From: Claire Richardson
Sent: 11 April 2022 12:01
To: Teresa Harlow
Cc: Phil Champion
Subject: RE: 2021/93051 - Fieldhouse Lane bridge, Huds HD1 1AG Highways comments re surfacing

2. No works including any works of demolition shall commence until specifications of all construction and surfacing materials and a methodology for construction has been submitted to and approved in writing by the Local Planning Authority. Thereafter the development shall be constructed in accordance with the approved details and be retained thereafter.

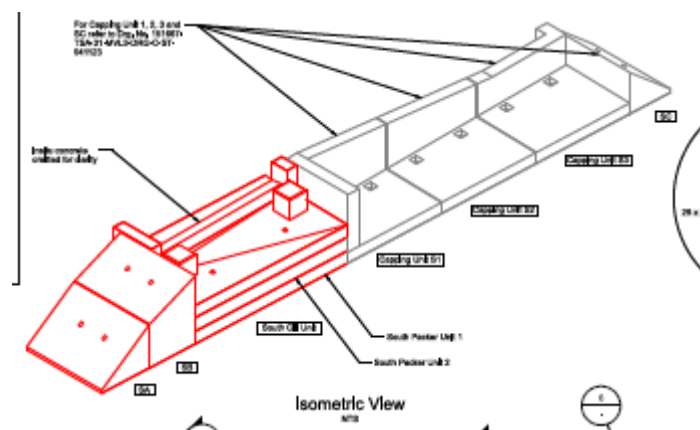
- iii. “Construction Info” document (page 2, Elevation A-A) cites “Combined non-slip waterproofing and surfacing to bridge deck plates...” This is in line with our requirements for the bridge deck surfacing material.

- iv. “Construction Info” document also cites “note 15” in the same annotation, which we cannot find. Is this pertinent to the approval?
- v. The surfacing material of the steps is cited as 6mm thick GRP tread with nosing. It is assumed that this will be a non-slip finish - I can’t find this confirmation in the documentation - NR should confirm this requirement.

- vi. “Construction Info” document (page 3, Section E-E) cites unreinforced concrete with a brushed finish to the “dog-leg” ramp, which contradicts drawing no 151667-TSA-31-MVL3-DRG-T-LP-162115, which shows a

granular construction ("Section C-C" and "Typical section through ramp"). We have already agreed the concrete finish with NR in discussions about the bridge and PRow.
